Department of Primary Industries

OUT14/40587

Penrith Lakes Scheme (DA 1 Mod 1) Proposed Modification

NSW Office of Water recommended condition of approval

Figure 5 – Residual materials consolidation area location

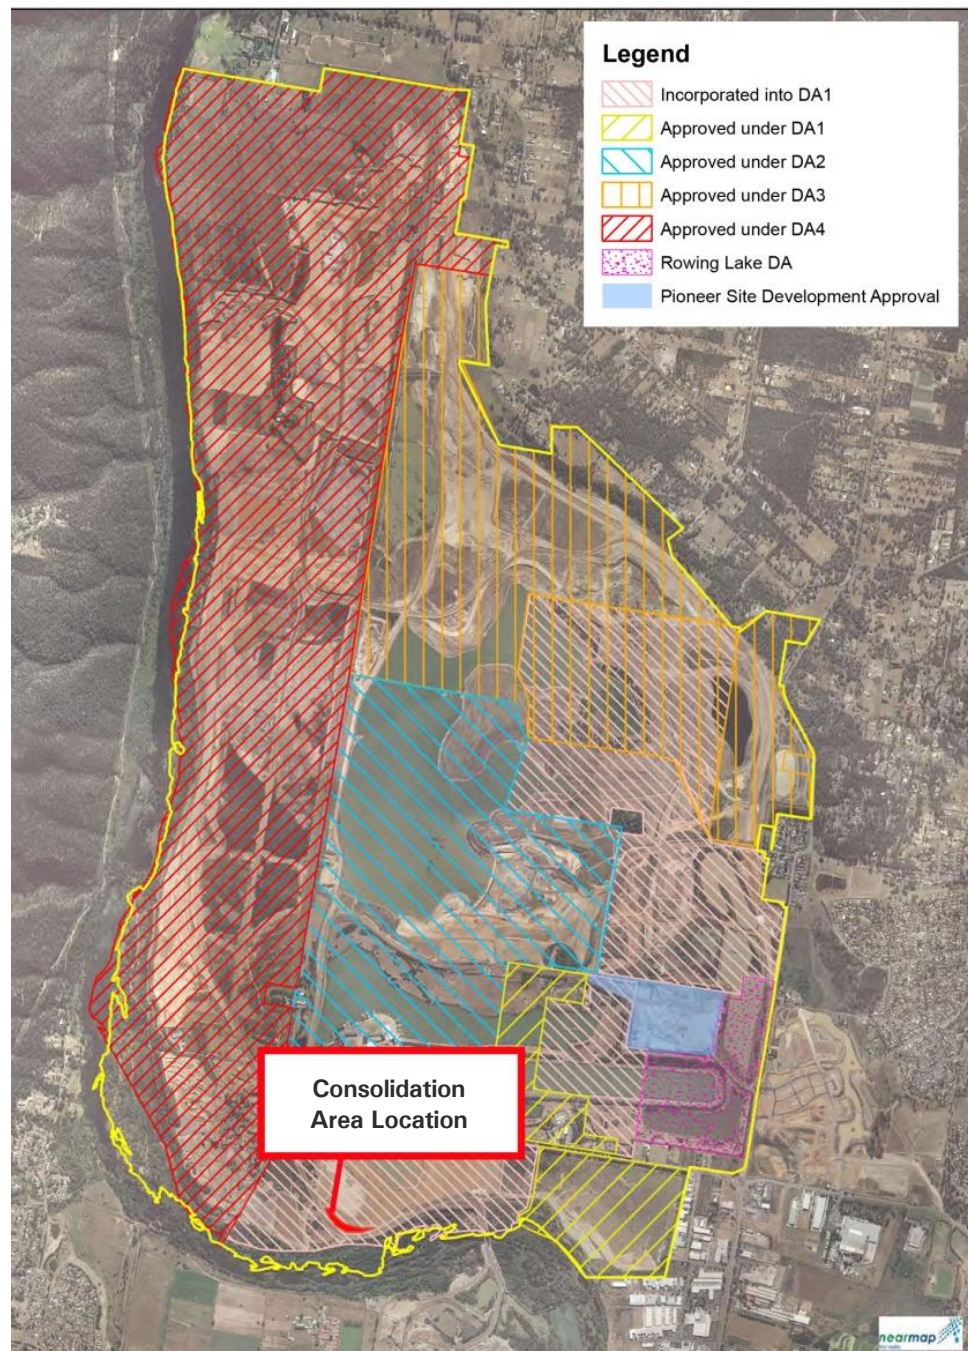
The report claims that as the base of the proposed residual materials consolidation area is at a minimum of 10m above the level of the Nepean River, and similarly above the water-level that will be created in nearby lakes system and the underlying groundwater level, the proposed modification is unlikely to impact on existing groundwater flows. Evidence of groundwater levels relevant to the proposed consolidation area should be provided to substantiate this claim.

I note that the physical barrier of the residual materials consolidation area would include a 500mm thick highly impervious clay seal, which will minimise the amount of water infiltrating into the residual materials consolidation area and so will minimise the amount of water coming into contact with buried residual materials. While it is claimed that the inert dry materials proposed to be consolidated are relatively stable in the natural environment and are not characteristic of products that generate contaminated leachate, the NSW Office of Water would prefer the entire consolidation area to be clay-lined to prevent any potential contamination of the local aquifer, unless evidence of isolation of the consolidation area from the aquifer can be provided.

The proposed location of the consolidation area appears to be on the outside bend of the Nepean River, making it more susceptible to erosion during floods. As such, the geomorphic implications of this proposal need to be explored to ensure that the disturbed area will not be significantly impacted during periods of floods and high flows over the site.

1. Works on waterfront land (as defined in the *Water Management Act 2000*) are to be conducted in accordance with the NSW Office of Water's Guidelines for Controlled Activities.
